**From:** [Chadwick, James \(E,I&S\)](#)  
**To:** [Oaklands Farm Solar](#)  
**Cc:** [Parkinson, Mark \(E,I&S\)](#); [Evans, Mark \(E,I&S\)](#)  
**Subject:** Oaklands Solare Farm Issue Specific Hearing 1  
**Date:** 18 October 2024 10:54:01  
**Attachments:** [image001.png](#)

There are effectively three matters outstanding between us and the applicant, these are summarised as:

1. Requesting that route 2B is used in conjunction with 2A.
2. Insufficient provisions for the highway authority to recoup costs and/or approve remedial works to the construction traffic route.
3. Not convinced the compliance provisions in the OCTMP are suitably robust.

Figure 10.4: SCENARIO 2B BACK-UP CONSTRUCTION VEHICLE ROUTING

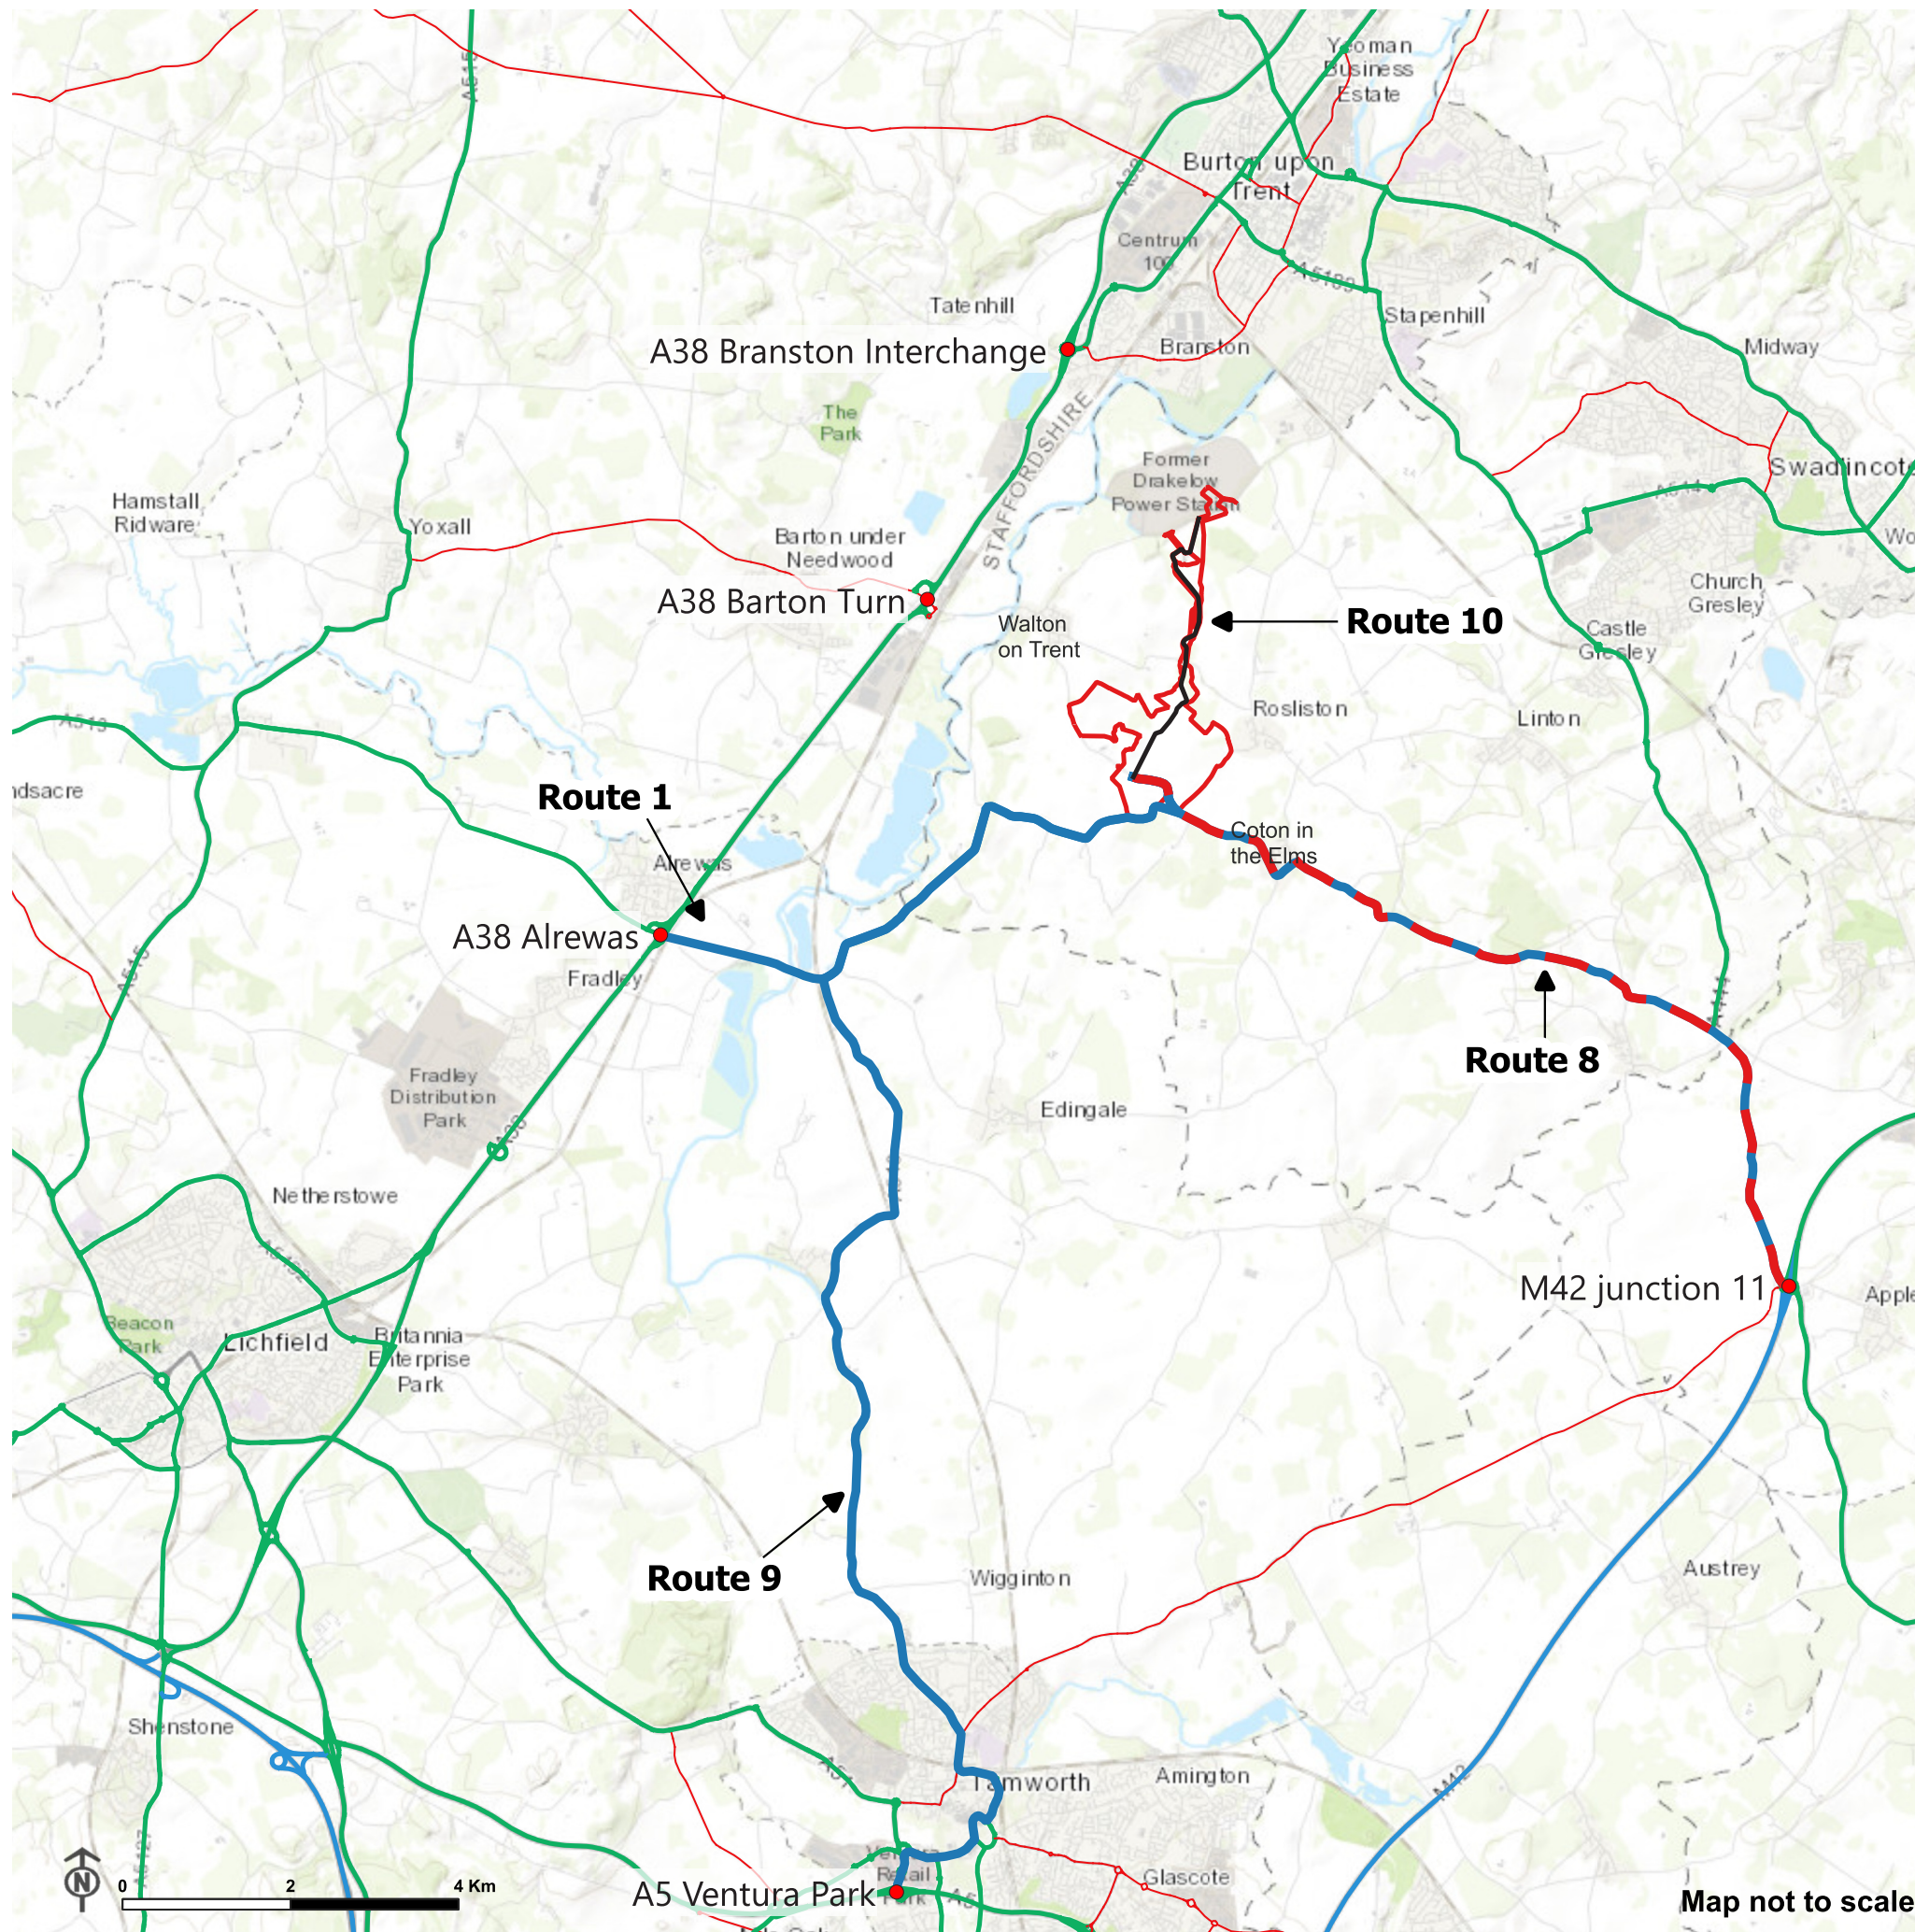
1. The Applicant's response to ExA Q2, 11.4 [REP4-011] elaborates on the rationale that Scenario 2B would only be suitable to use should an obstruction or closure make Route 6 under Scenario 2A, unusable. Do SCC require further clarification?  
[Our issue is that the assessments have only considered the impact of the routes being used in isolation. No work has been conducted to demonstrate that the impact on Stapenhill residents can be lessened by spreading some of the HGV traffic onto route 2B without adverse impact on route 2B.](#)
